1.0 Introduction

- 1.1 This Technical Note response to comments from the Local Highway Authority (LHA) dated 17th November 2022. For completeness a copy of the comments is enclosed in **Appendix A**.

Application no: 22/01611/OUT

Location: Stratfield Farm 374 Oxford Road Kidlington OX5 1DL

Proposed Site Access  
MAC drawing no. 122-TA05D – Access Design

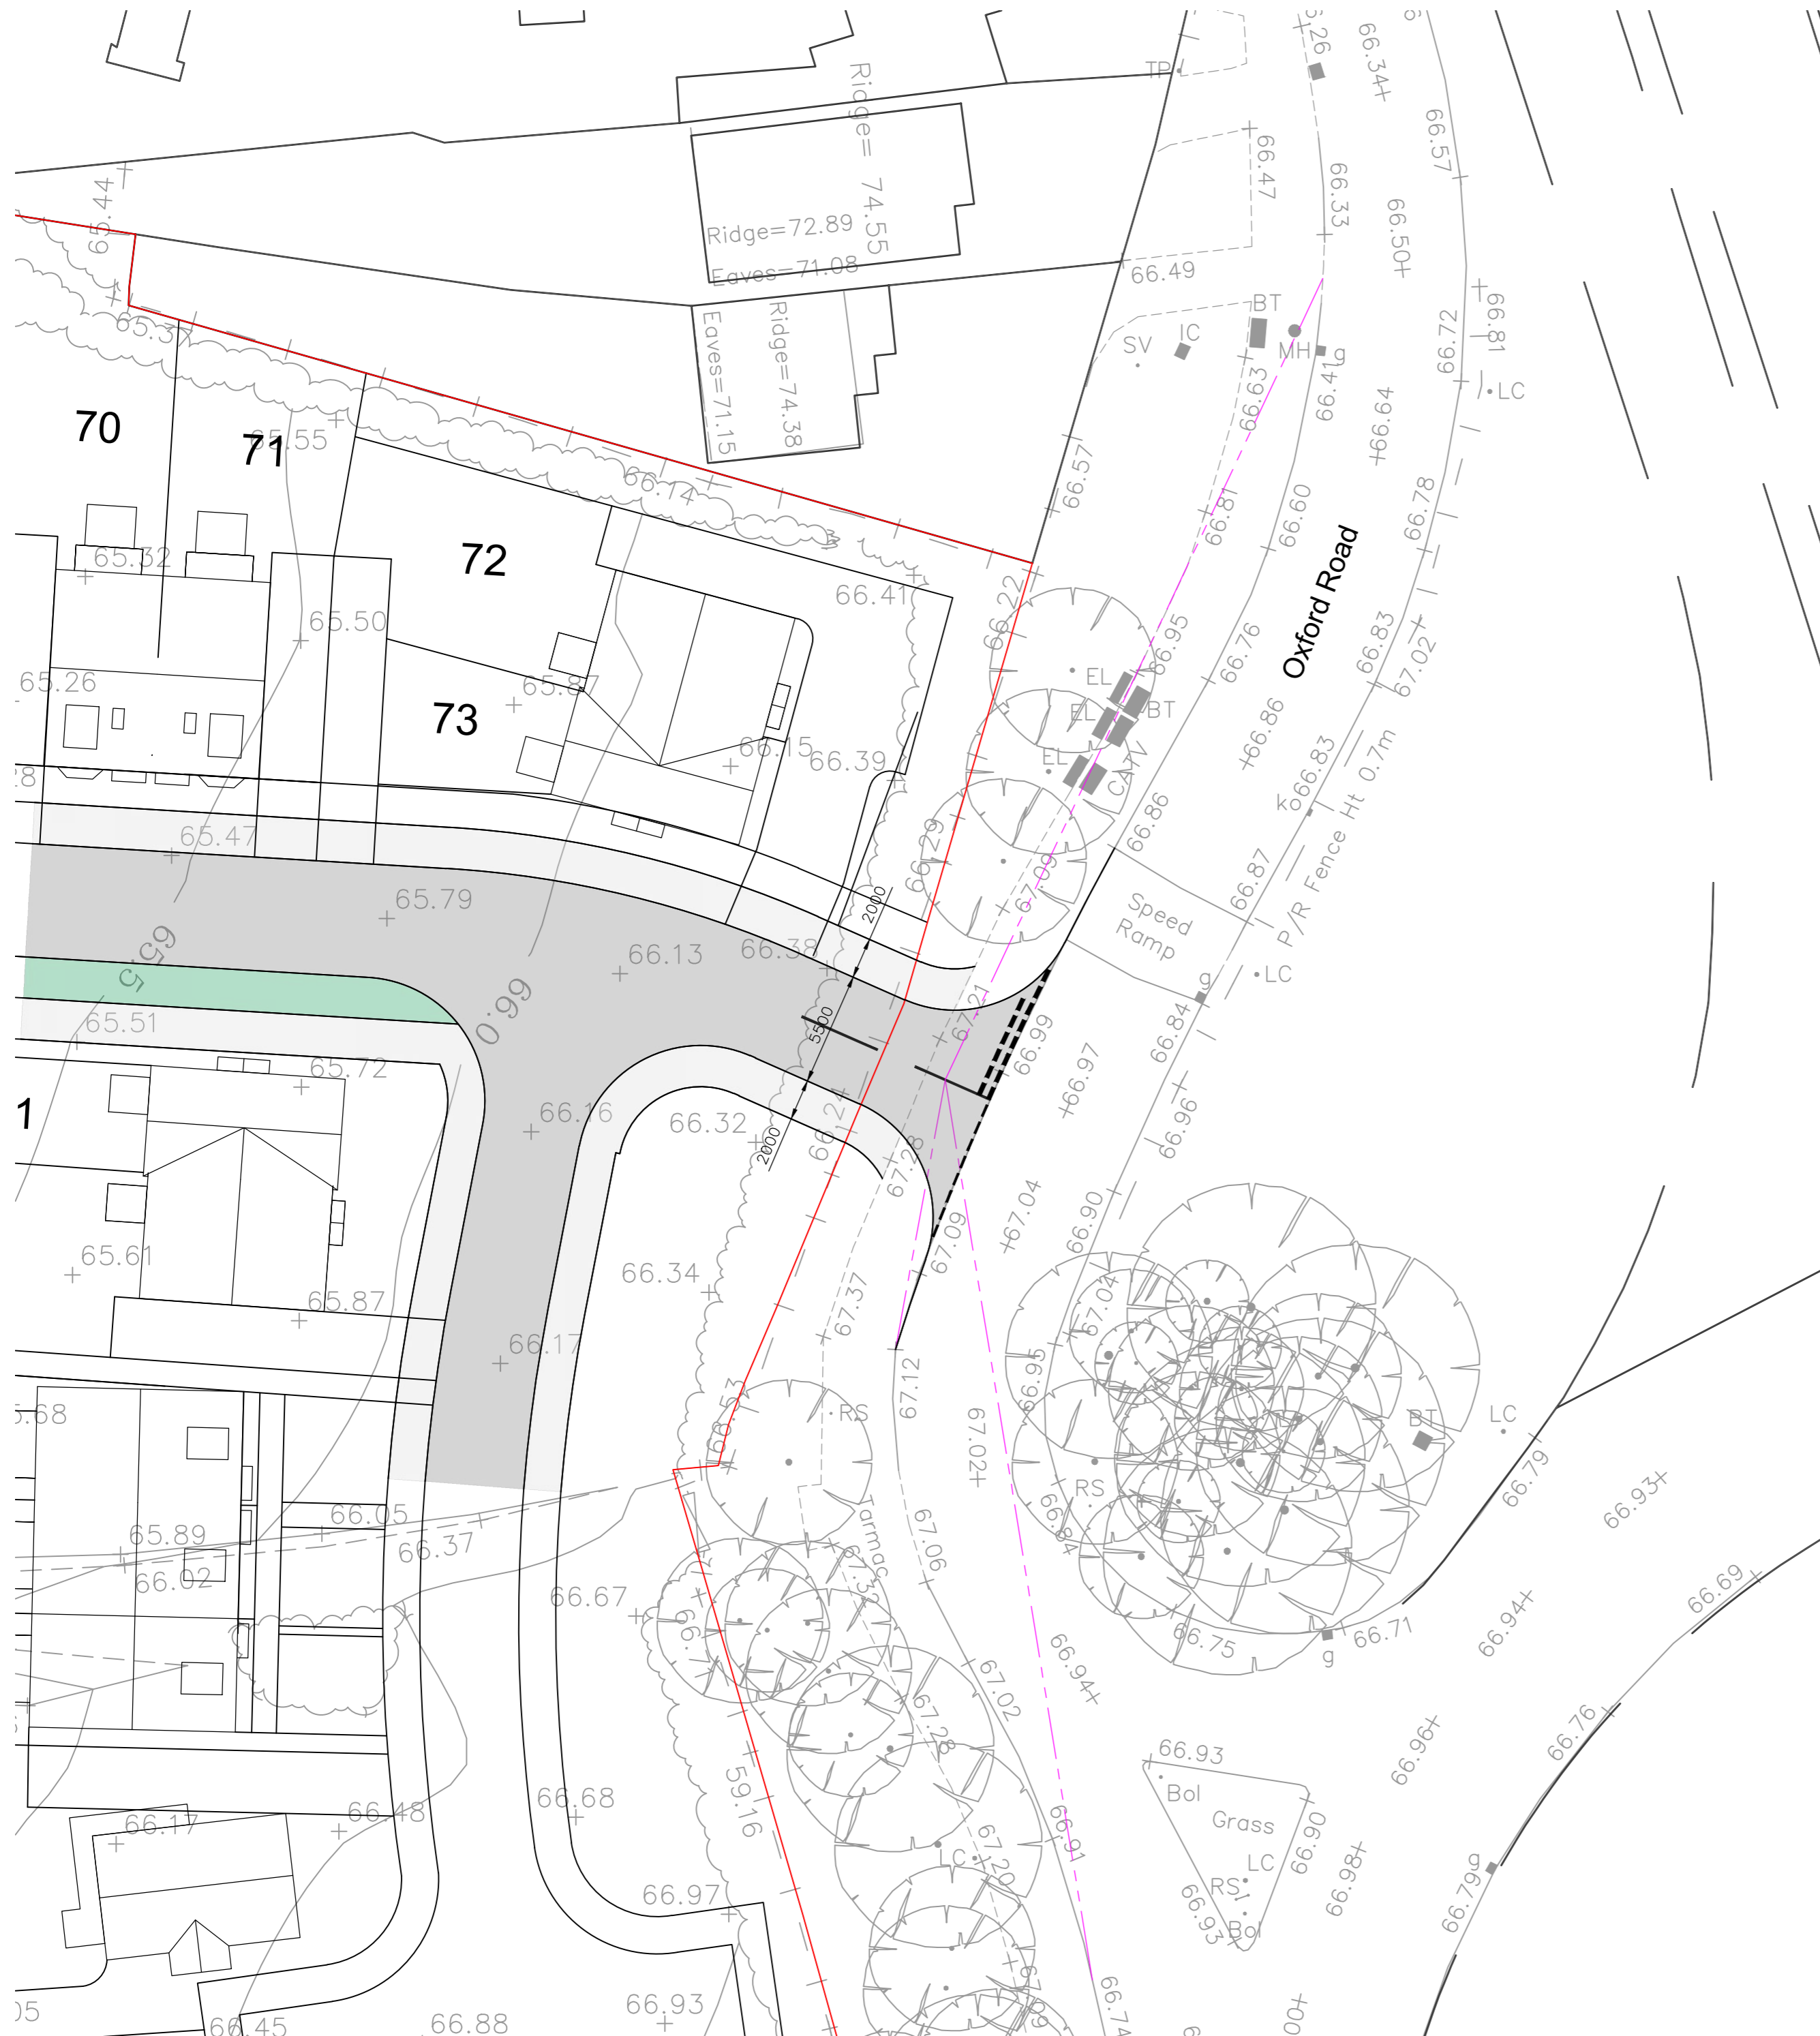
- The 2.0m wide footway either side of the site access does not clearly show how these transition into the existing 3m+ wide along Oxford Road. The proposed footway as illustrated by *Drawing No: 122-TA05 Rev E* shall need to be extended to cover the extent of the bellmouth + a kerb length. The arrangement must also include dropped kerbs and tactile paving. You will be aware that this point is a crucial link for walking and Cycling that must not be left undermined. **To be conditioned.**

- A gap is still in place at the point where the proposed shared footway/ cycleway terminates at the south eastern corner of the red application line. (see snippet in our previous response). This has not been addressed by the TN. Now that the applicant has the benefit of the proposed Kidlington roundabout schematic drawing, the application must show how the proposed shared facility would tie into the shared use path of such a vital committed scheme. **This remains an objection in detail rather than in principle.**

- 2.2 An updated access drawing enclosed in **Appendix B** shows the footway / cycleway connection in the south eastern corner connecting with the existing footway / cycleway on the adjacent highway. Based on the plans we have there are no changes to the footway / cycleway provision as a result of offsite improvements by others within the vicinity of the site.
